# ***City of Albuquerque***

April 15, 1996

RE: REVISED GRADING AND DRAINAGE PLAN FOR BANK OF AMERICA, TRACT C-8 OF COTTONWOOD MALL (B12/D12), SUBMITTED FOR SITE DEVELOPMENT PLAN FOR BUILDING PERMIT AND BUILDING PERMIT APPROVAL, ENGINEER'S STAMP DATED 3/14/96.

DRAINAGE AND GRADING PLAN
 TRACT C-8 COTTONWOOD MALL

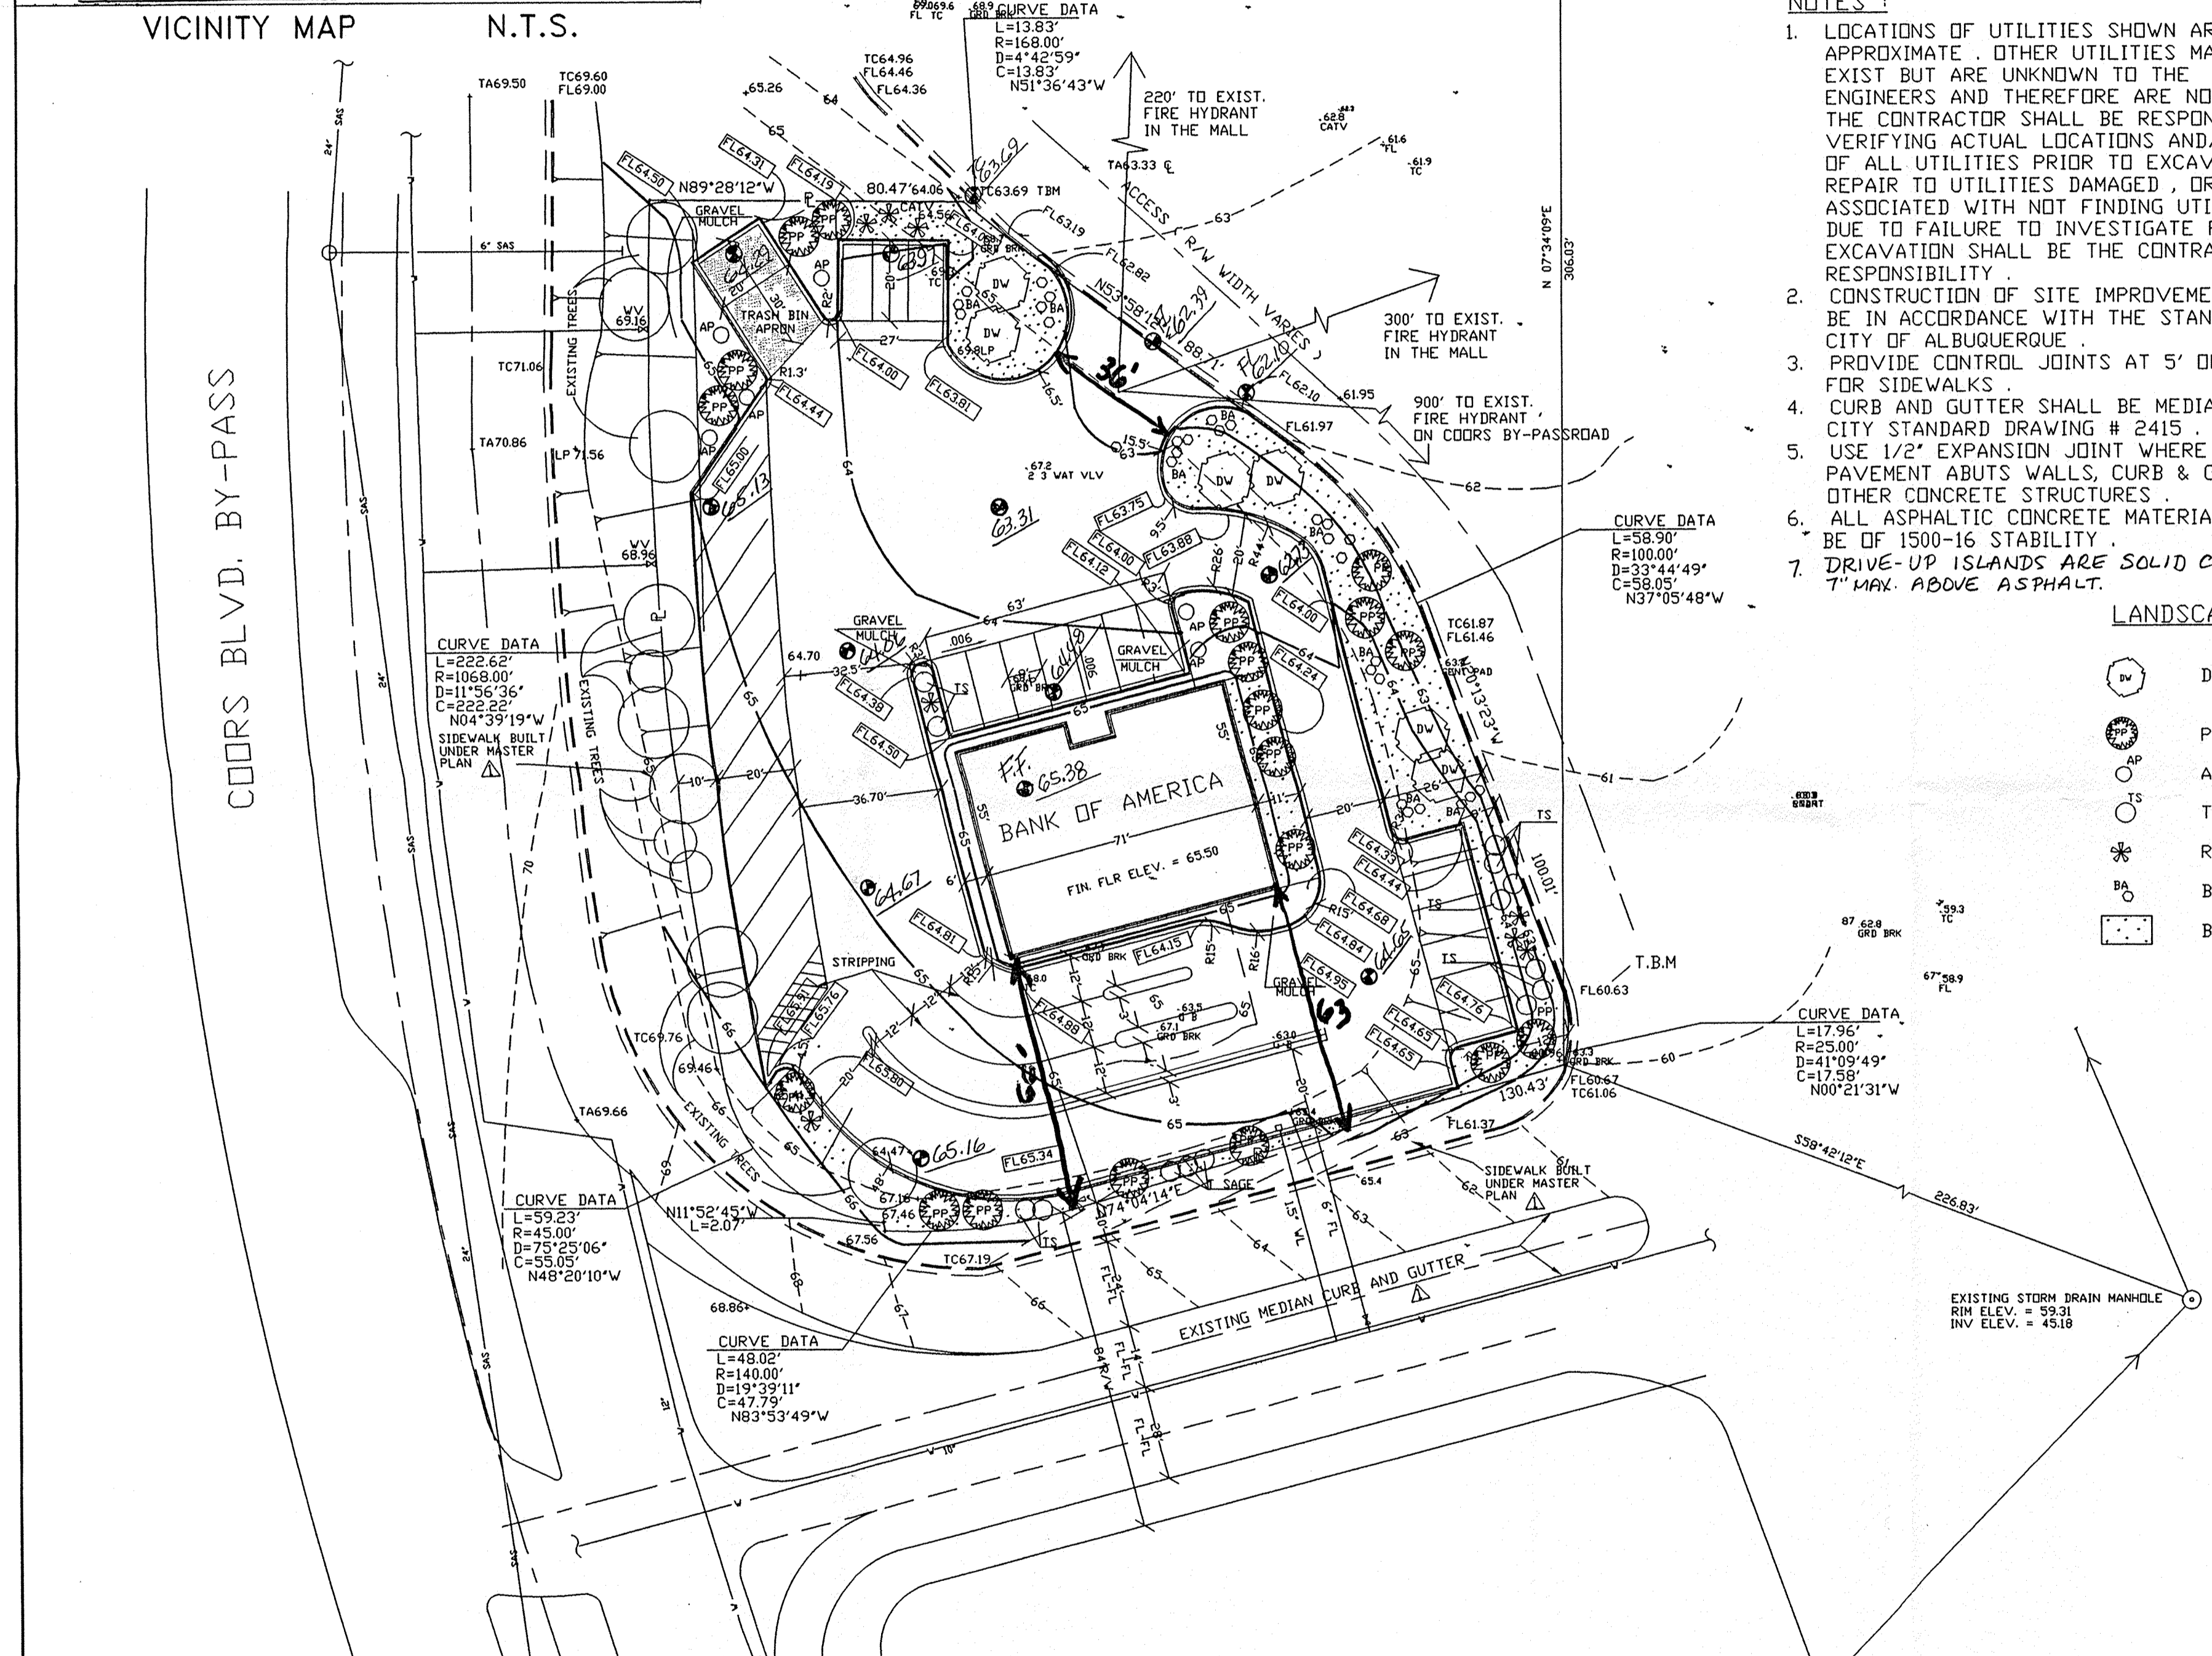
Based on the discussion we had with Mr. Kerry Davis of Bohannon-Huston, Inc., the drainage concept presented on above referenced plan is acceptable. However, the grading and drainage plan does not match the Site Development Plan, therefore it cannot be approved for Building Permit release. Please be sure that the dimensions which were required by Transportation are shown accurately on the resubmitted drainage plan.
